CITY OF ALBUQUERQUE

RE: **Costco**
1420 Renaissance Blvd. NE
Grading and Drainage Plan
Engineers Stamp Date 12/1/2021 (F16D003G)

Based upon the information provided in your submittal received 3/3/22, this plan cannot be approved until the following corrections are made:

GRADING AND DRAINAGE PLAN

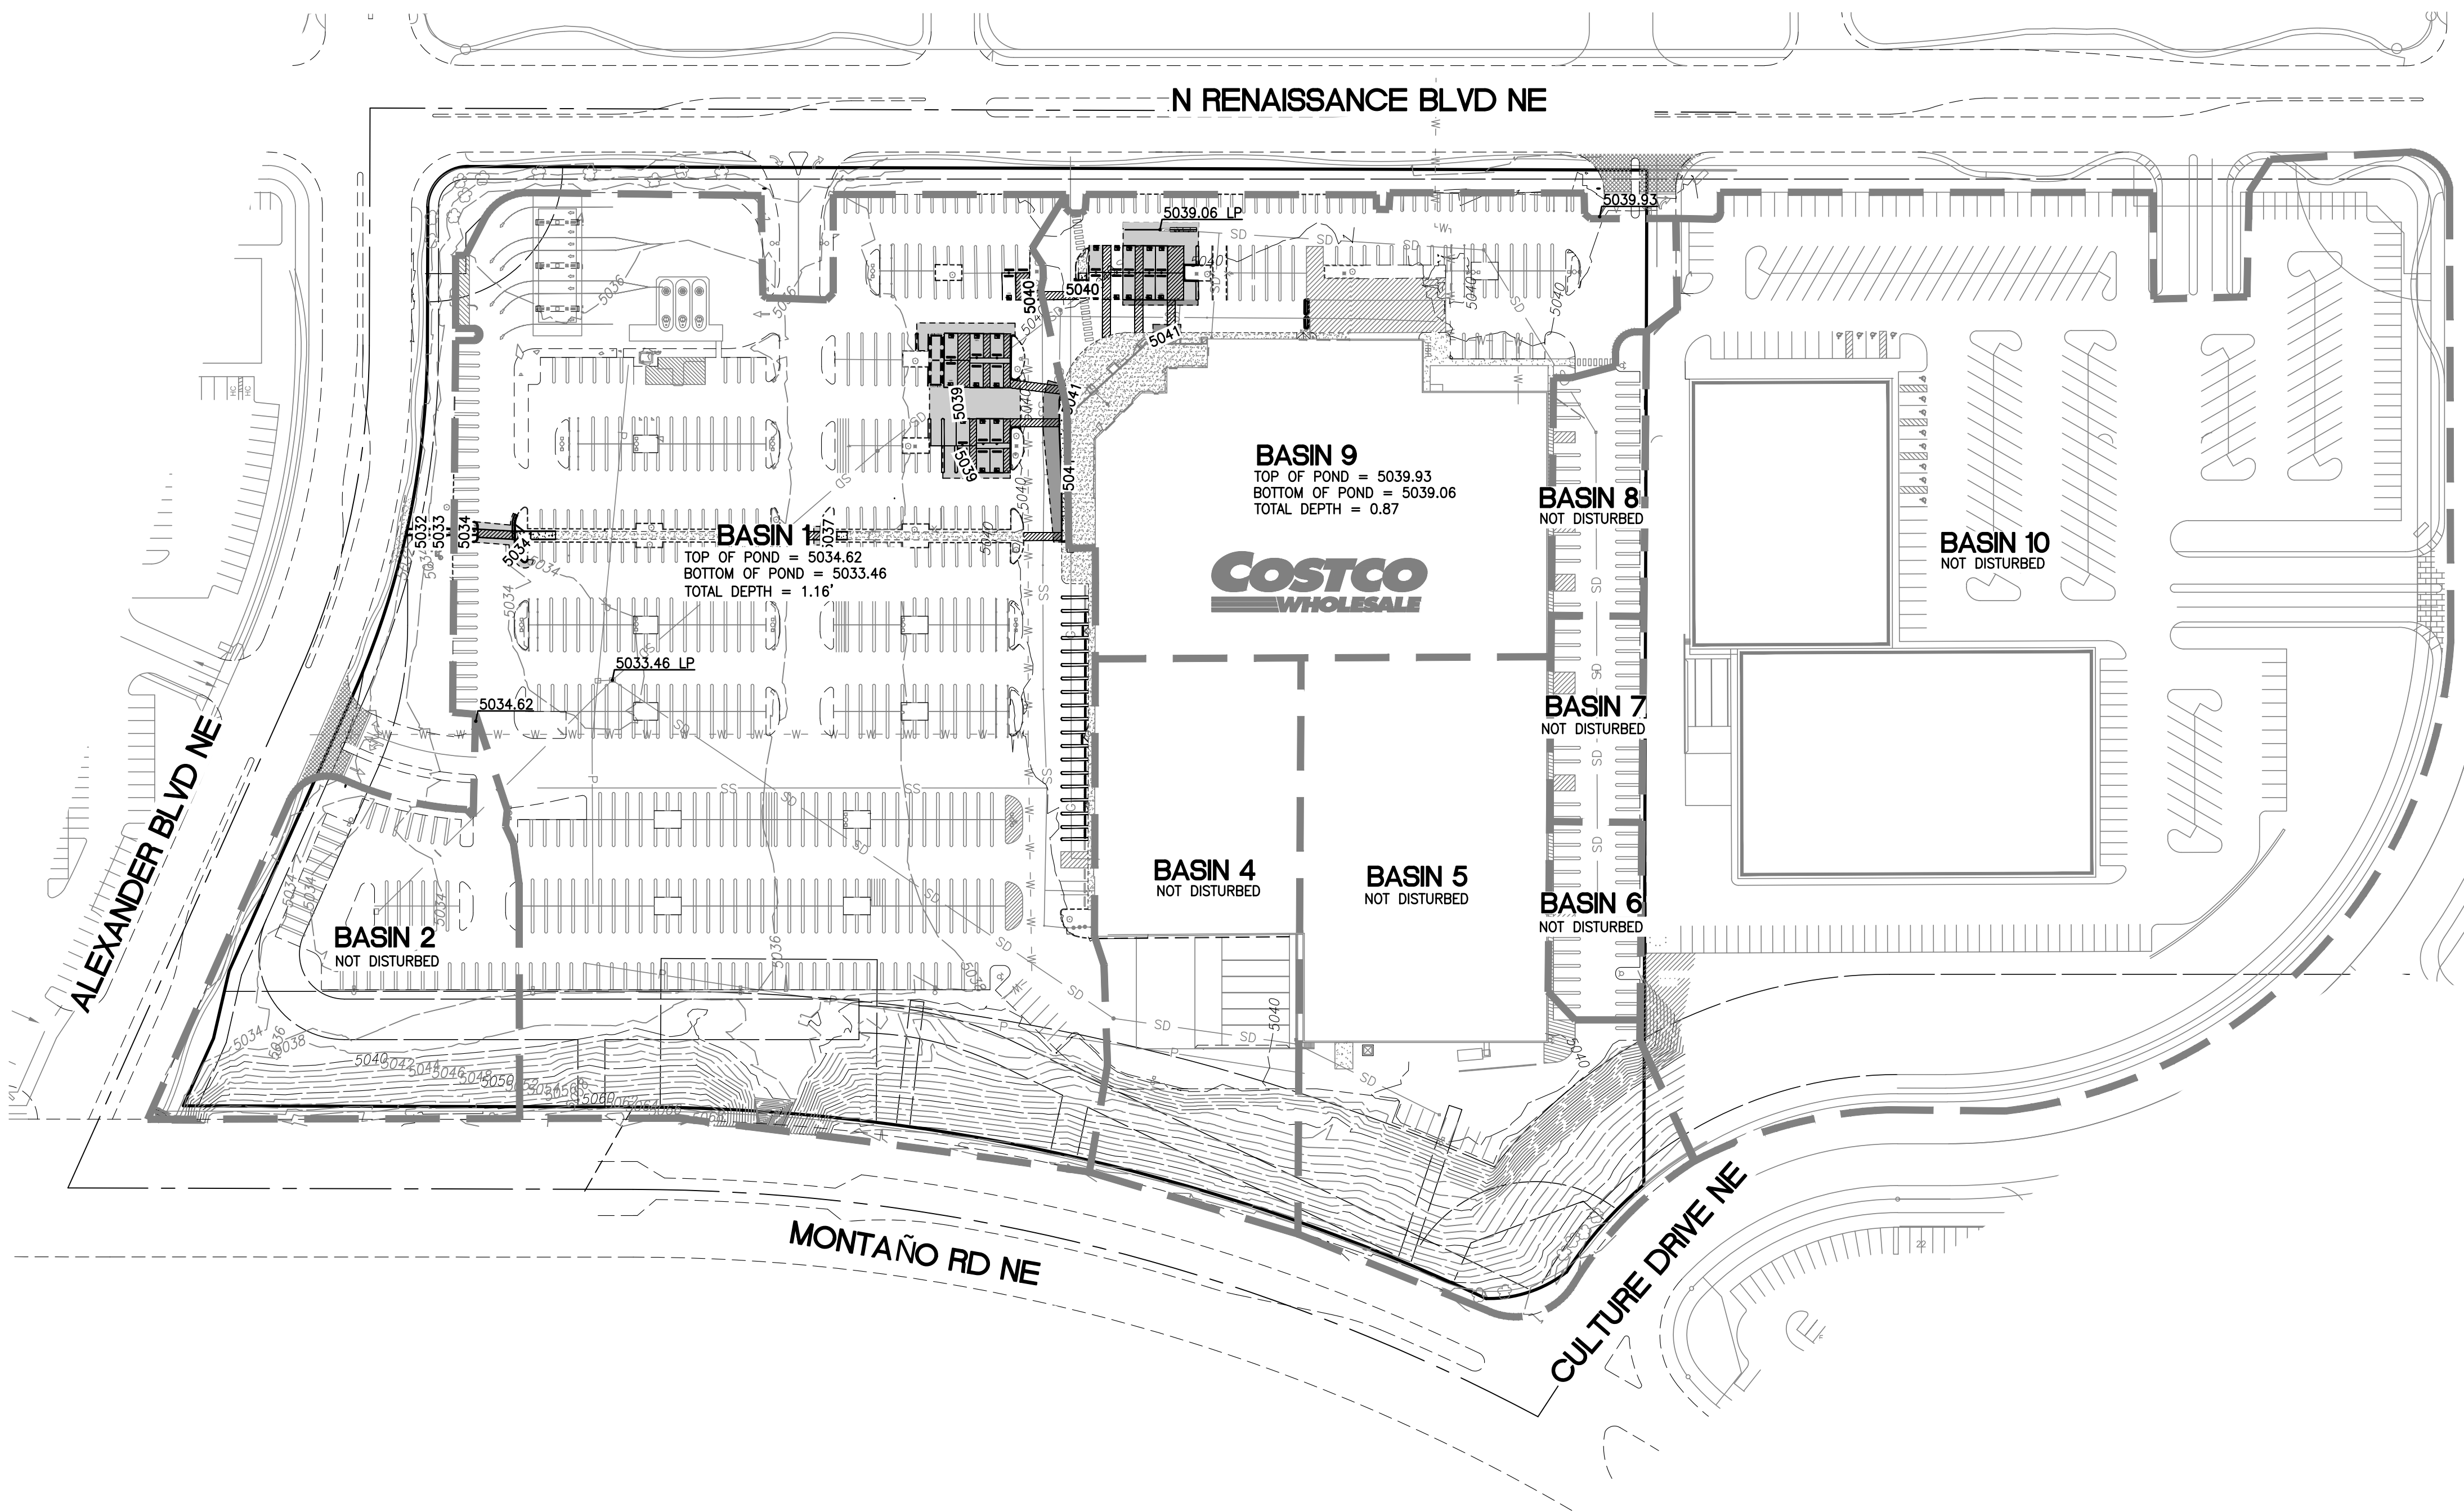
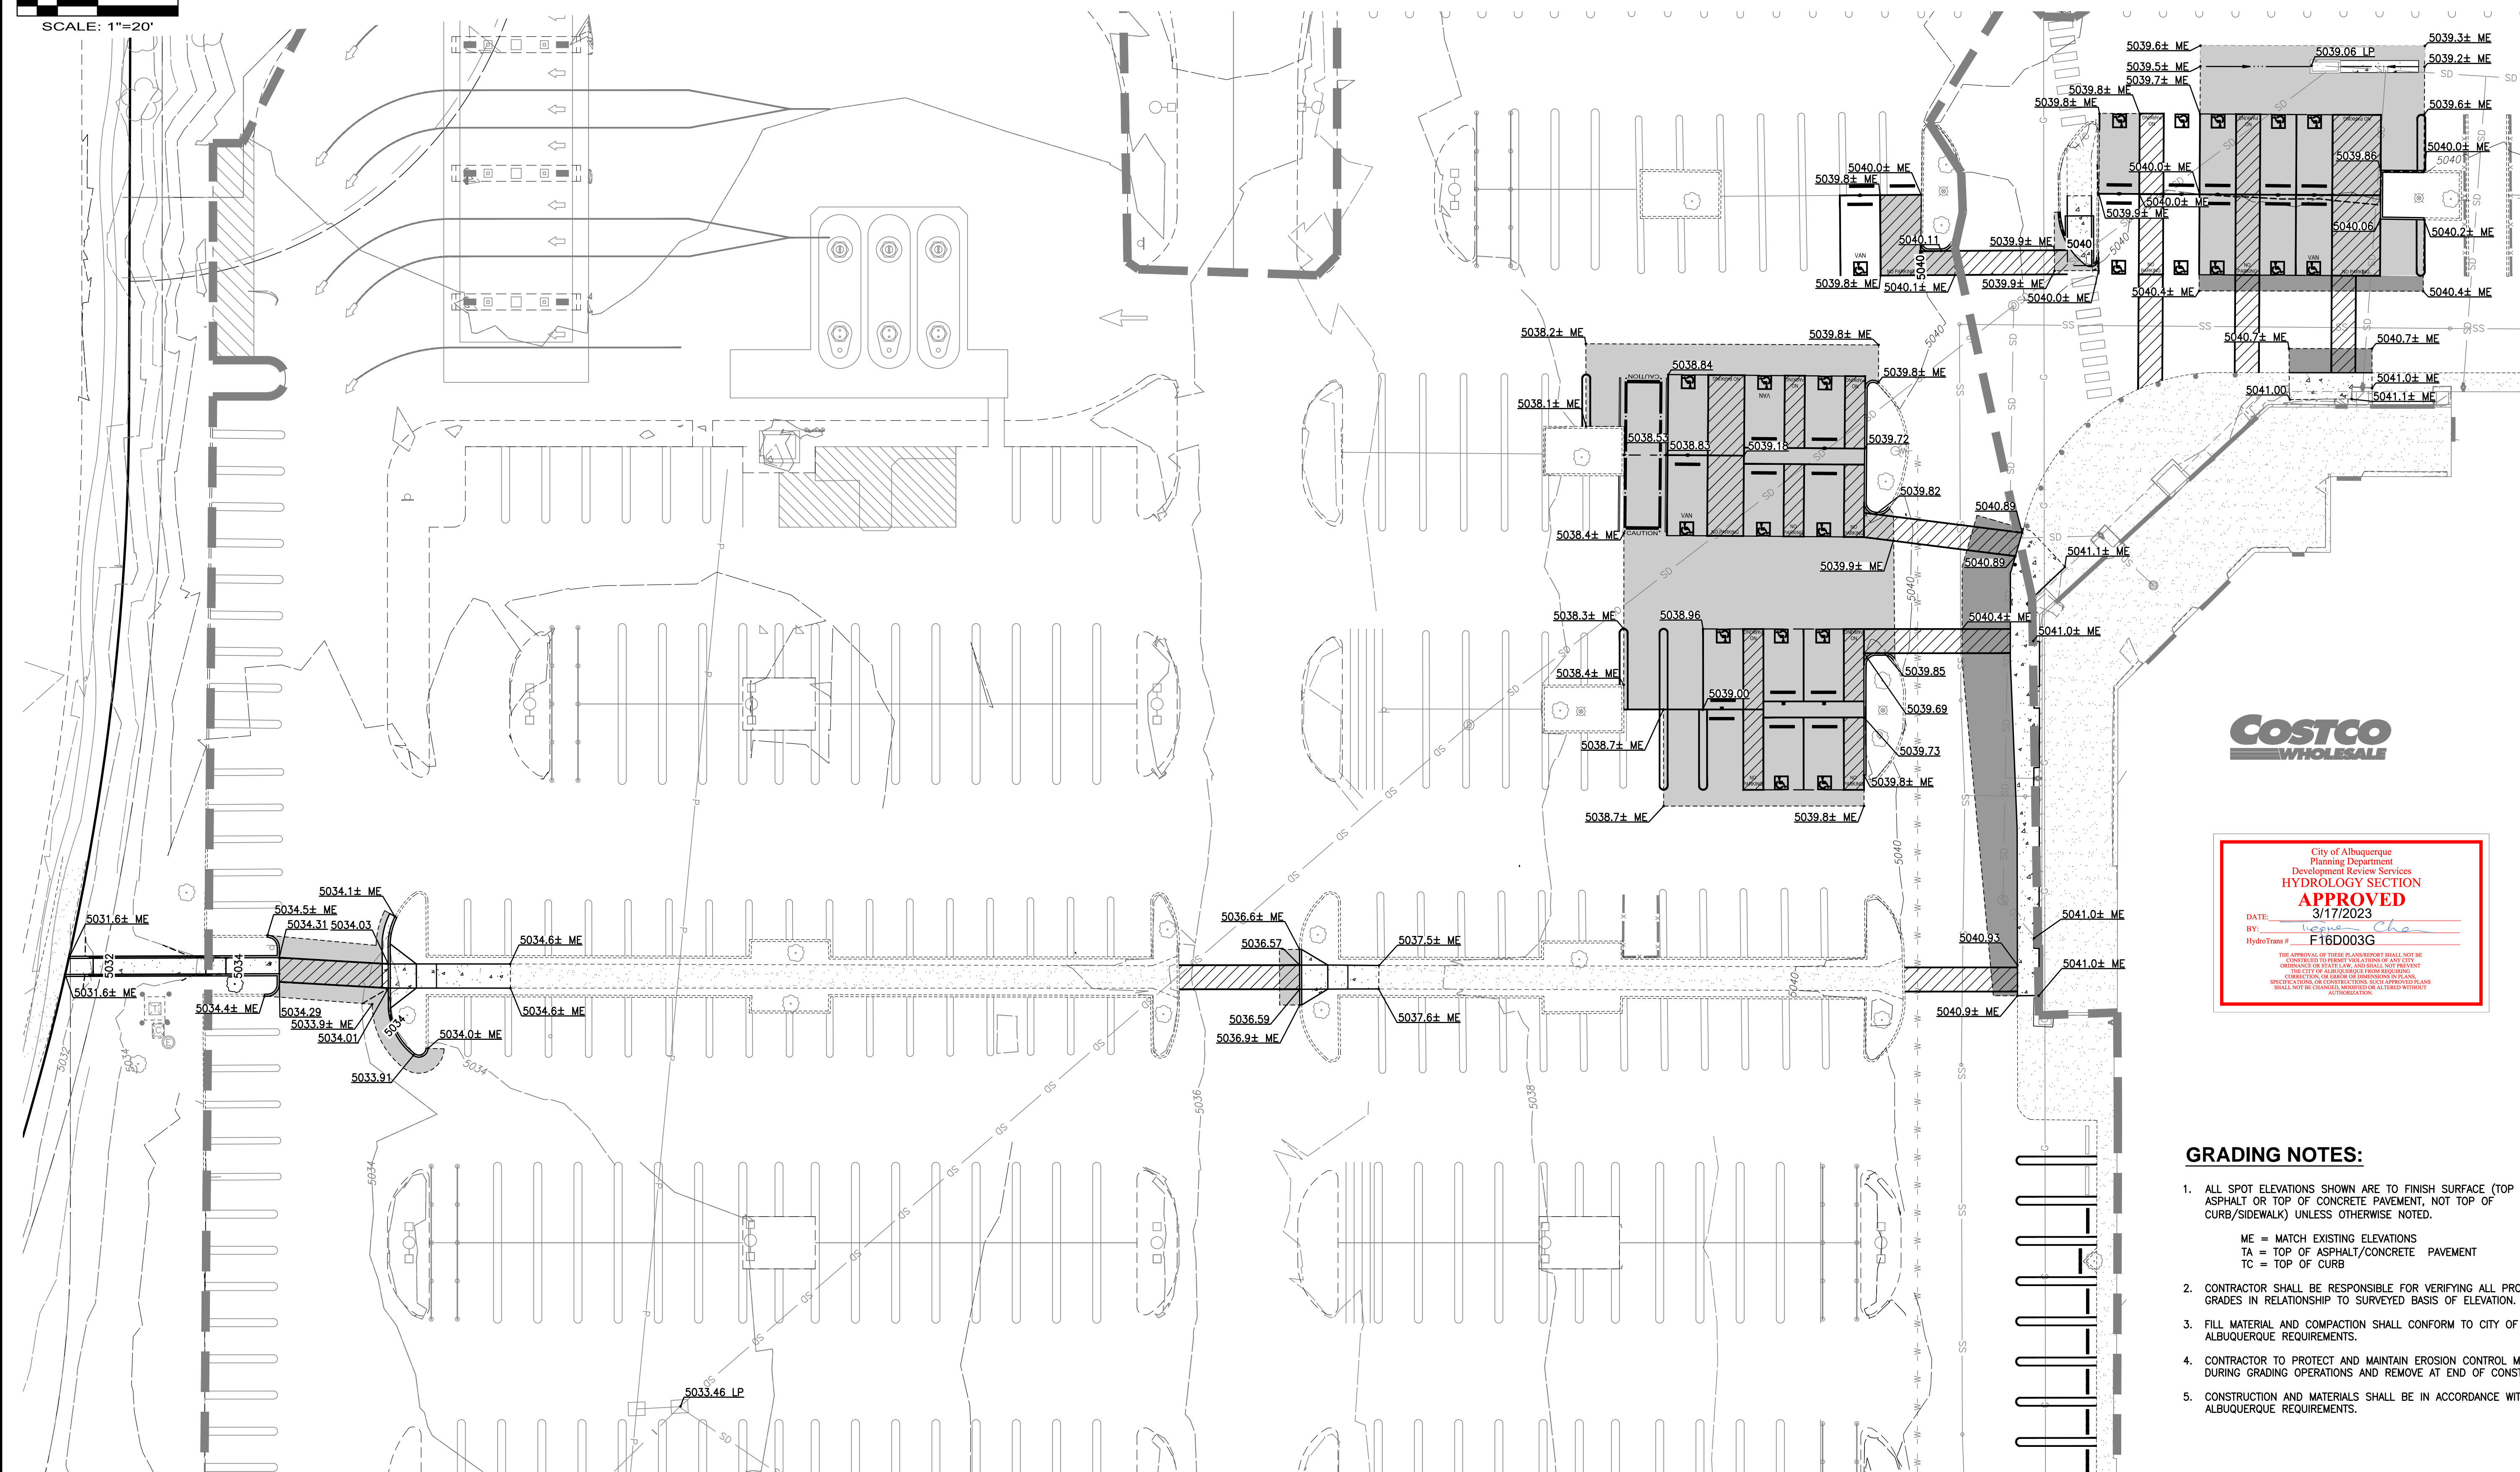
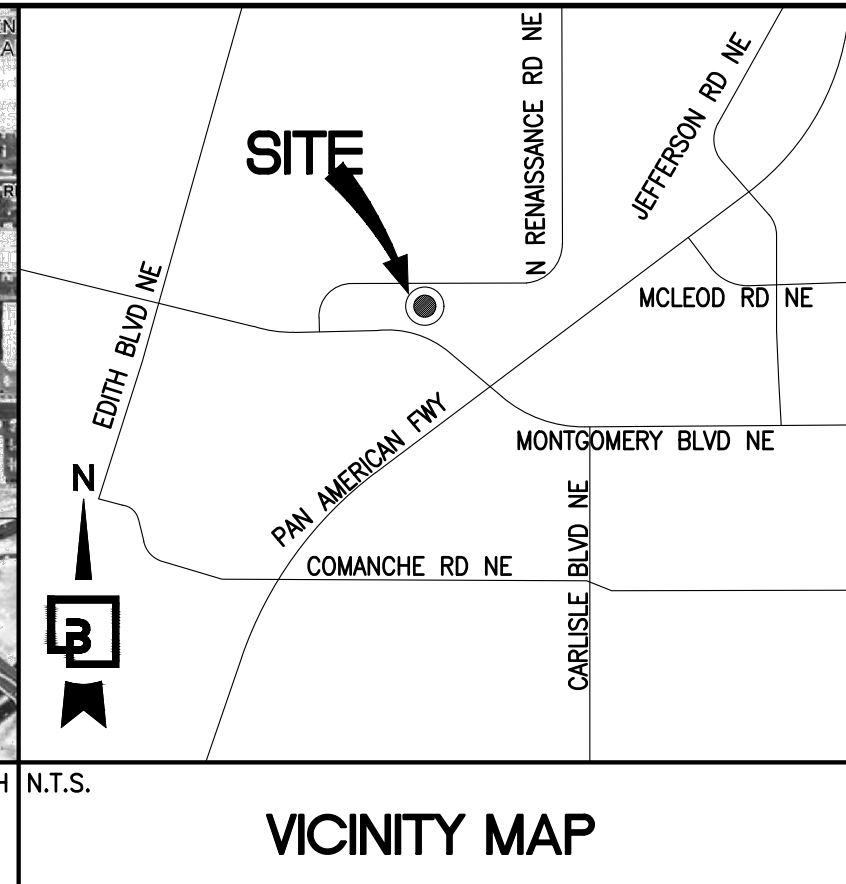
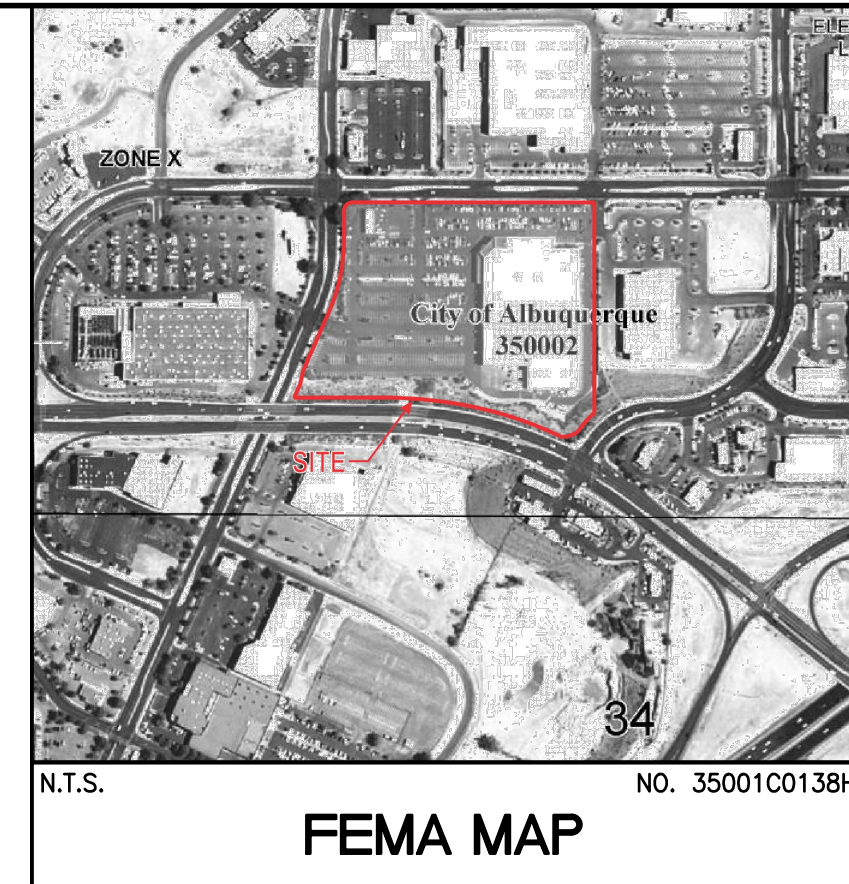
2. Per the DPM, the following must be on the Grading Plan. Please ignore any items that are already part of your plan:
 - a. Please provide an engineer's stamp with a signature and date.

- b. Please use 1" = 20' or larger for the scale.
 - c. Please provide a Vicinity Map.
 - d. Please provide the Benchmark information (location, description and elevation) for the survey contour information provided.

- e. Please provide the FIRM Map and flood plain note with effective date.
 - f. Please provide a legal Description of the property.
3. There are no calculations shown for runoff and ponding. Please use the procedure for 40 acre and smaller basins as outlined in Development Process Manual (DPM) Article 6-2(a). Please provide both the existing conditions and proposed conditions for the 100 year-6 hour storm event.

4. Please calculate and provide management onsite for the Stormwater Quality Volume (SWQV) in accordance with the new drainage ordinance, § 14-5-2-6 (H) enacted 10/2/18

(Council Bill C/S O-18-2). Please show the top and bottom of the ponds along with the volume for each pond. The onsite drainage should be directed to these ponds prior to being collected in a private unground drainage system. Please follow the DPM (signed 06/08/20) Article 6-12 Stormwater Quality and Low-Impact Development for the sizing calculations. To calculate the required SWQV, multiply the impervious area draining to the BMP by 0.42 inches for new development sites and 0.26 inches for redevelopment sites. The calculations of both the required and the provided volume of each BMP must be shown on the Grading and Drainage Plan. Each BMP should be labeled on the Grading and Drainage Plan with the required SWQV and associated water surface elevation and the 100-year water surface elevation. Landscaping of surface BMPs is also required to be noted on the Grading and Drainage Plan. This site qualifies as redevelopment so use the smaller number.

- 5.
6. Please provide the SWQV calculations for each basin draining to each pond. The stormwater quality ponds need to be sized for the areas draining to them. Typically these flows are directed to landscaping areas which are graded to hold the SWQV.
7. I see on your plan that Grading Area 4 is proposed to use a CDS manhole to capture and treat storm flows. The City does not allow these types of systems to be used as once they are a maintenance problem and do not get serviced regularly. The City uses retention of SWQV in ponds or if need be in underground systems.
